M5 Junction 10 Improvements Scheme

dDCO Change Log
TR010063 - APP 9.21

M5 Junction 10 Improvements Scheme Development Consent Order 202[x]

Draft DCO Change Log

FOR CONTINUATION REFER TO SHEET 15

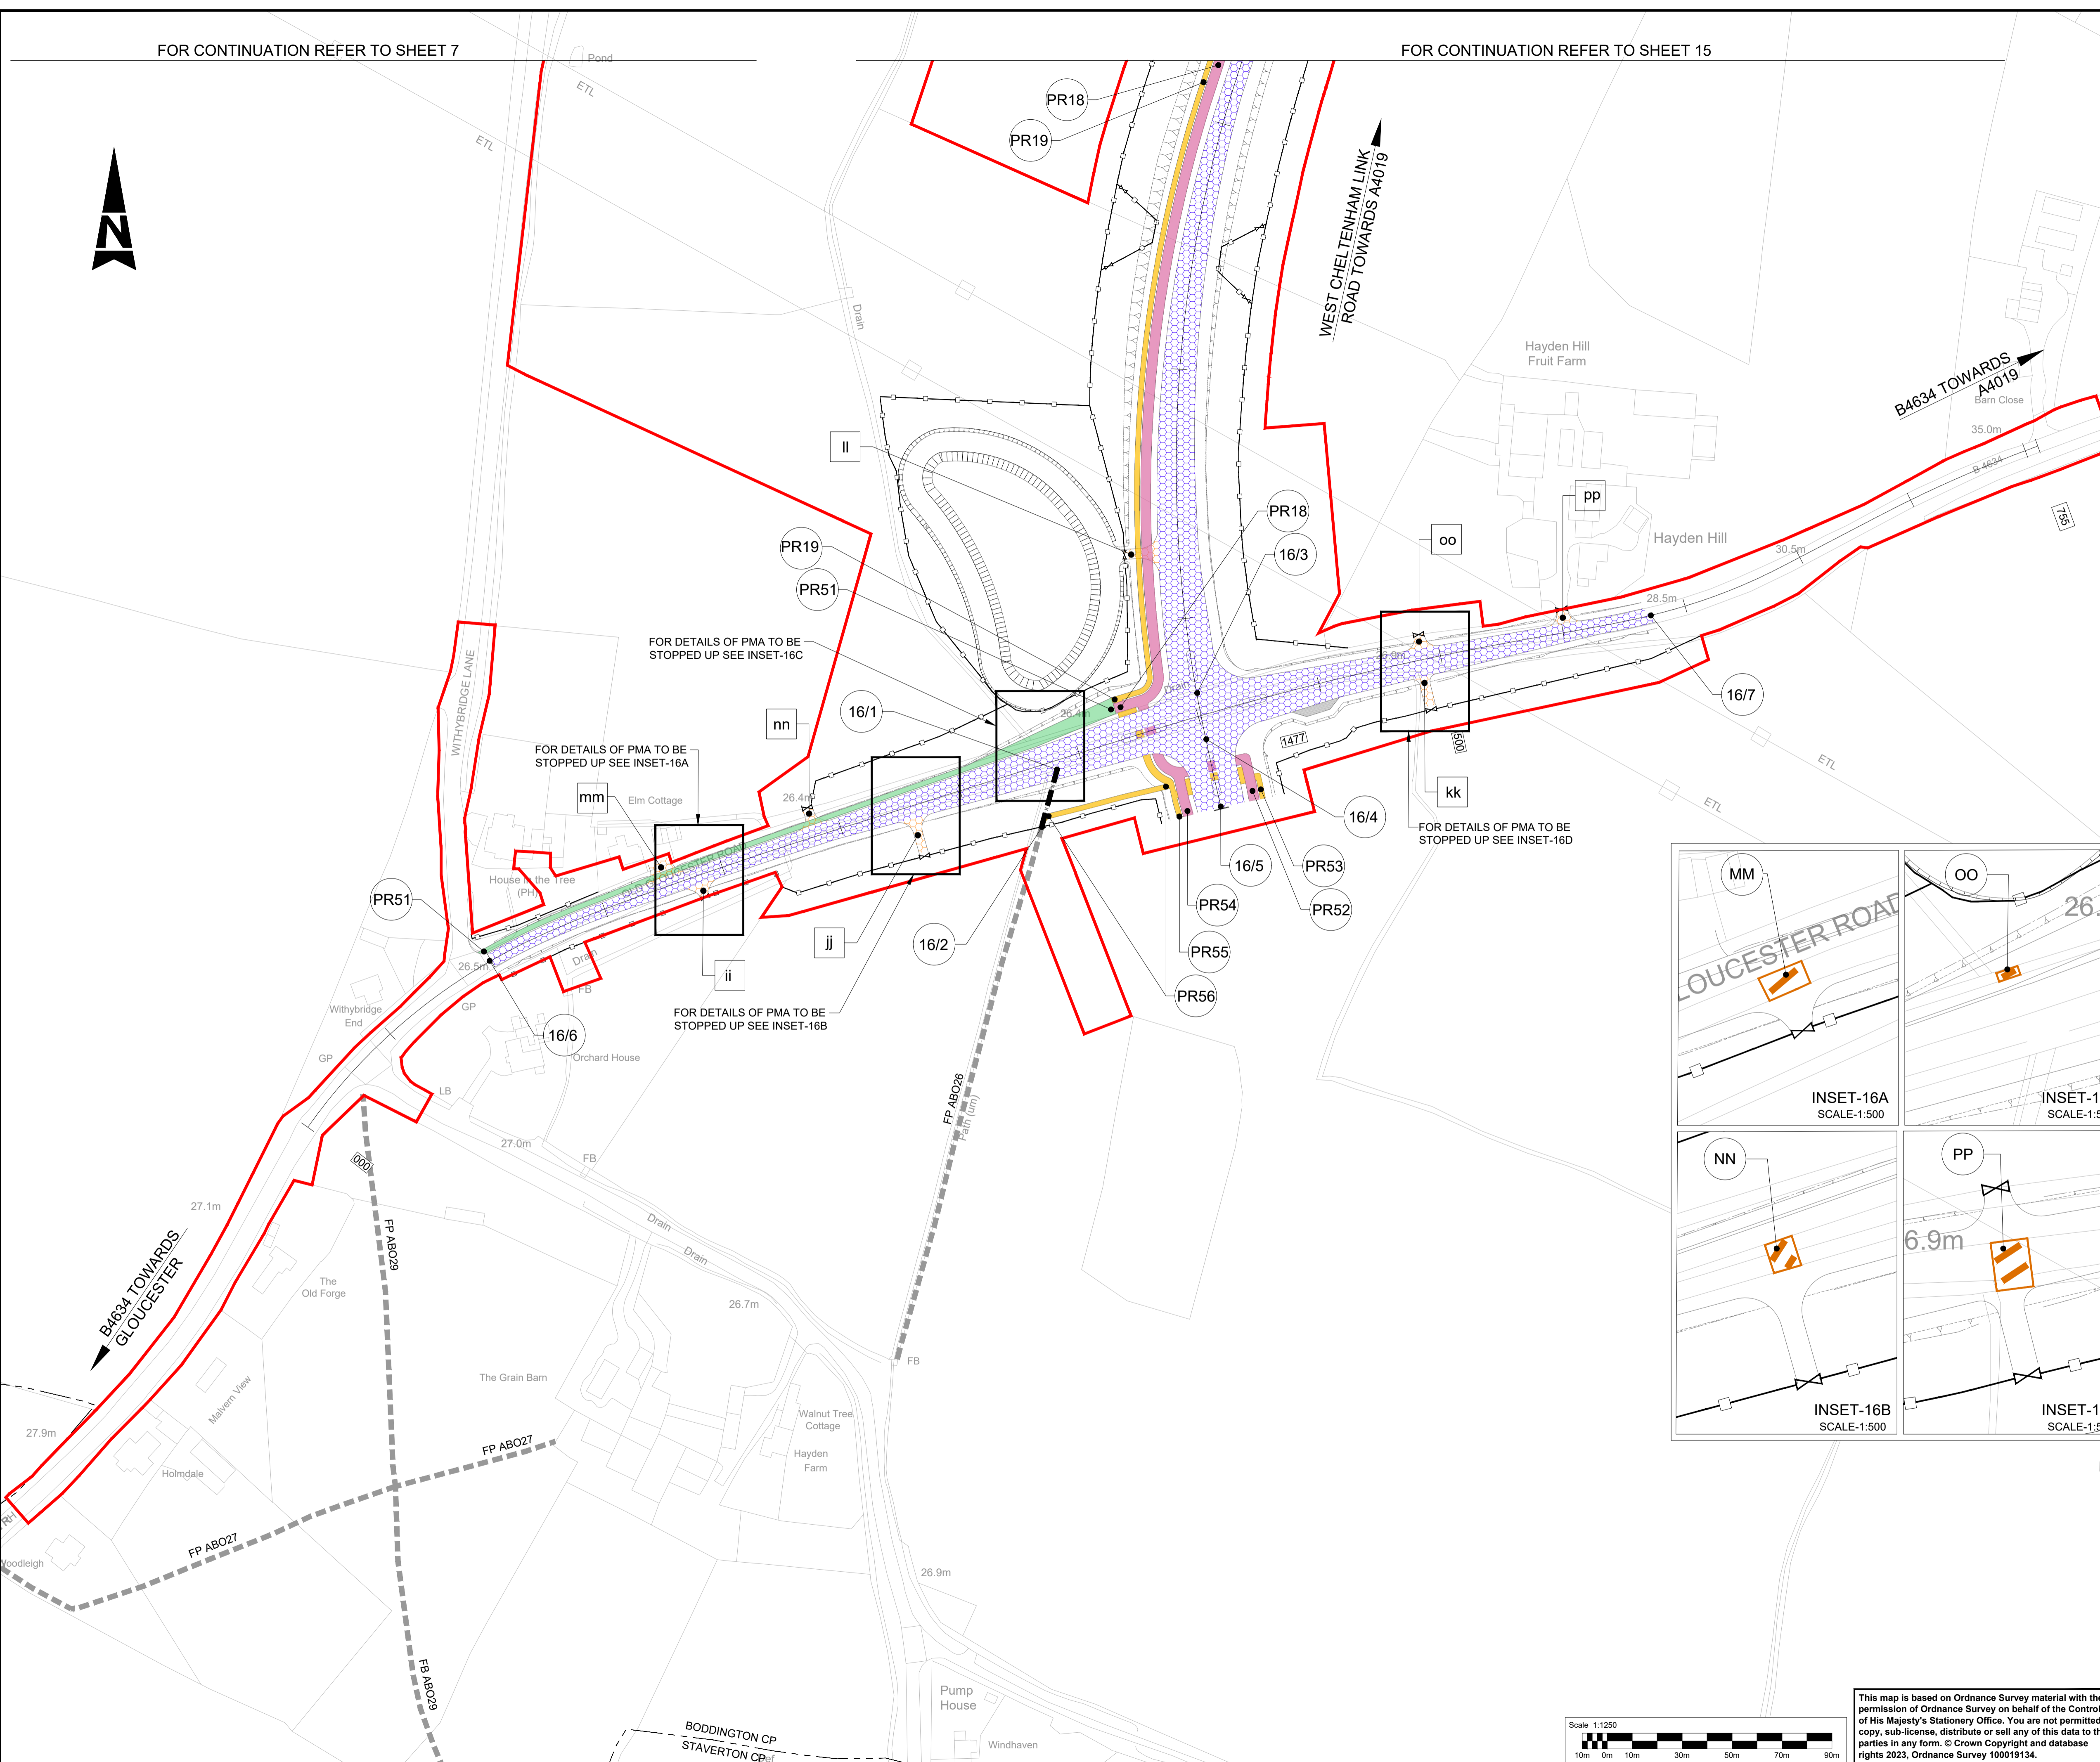
Schedule 3, Part 7	<p><u>PR49</u> 320-309 metres of footpath to the north of the River Chelt, rerouting the existing footpath ref. AUC11 under the new River Chelt Bridge, as shown on sheet 15 of the streets, rights of way and access plans</p>	To reflect changes made to the streets, rights of way and access plans which provide a minor realignment to the diverted public right of way.
Schedule 4, Part 2, Row 1	Column (3)	To reflect changes made to the streets, rights of way and access plans which provide a minor realignment to the diverted public right of way

<p>For a distance of 144<u>103</u> metres, as shown between points 15/1 and 15/2 on sheet 15 of the streets, rights of way and access plans</p> <p>Column (4)</p> <p>Reference PR49</p> <p>320<u>309</u> metres of new footpath to the north of the River Chelt, rerouting the existing footpath ref. AUC11 under the new River Chelt Bridge, as shown on sheet 15 of the streets, rights of way and access plans</p>	
Schedule 5, plot 3/2c	Removal of plot 3/2c to be inserted in Schedule 7	To align with changes to the Book of Reference, Statement of Reasons, Land Plans as a result of further engagement with National Highways.
Schedule 5, plot 4/1c	<p>New plot added to schedule which had been permanent acquisition. New rights required for work numbers 1a, 1c, 1e, 1n being:</p> <p><u>New right for the construction of motorway signage and associated cabling and ducting works</u></p> <p><u>New right for the construction of a new southbound exit slip from the M5 to the A4019</u></p> <p><u>New right for the construction of a new northbound entry slip from the A4019 to the M5</u></p> <p><u>New right for the construction of an environmental barrier adjacent to Barn Farm north of Junction 10 and west of the M5</u></p>	To align with changes to the Book of Reference, Statement of Reasons, Land Plans as a result of further engagement with National Highways.
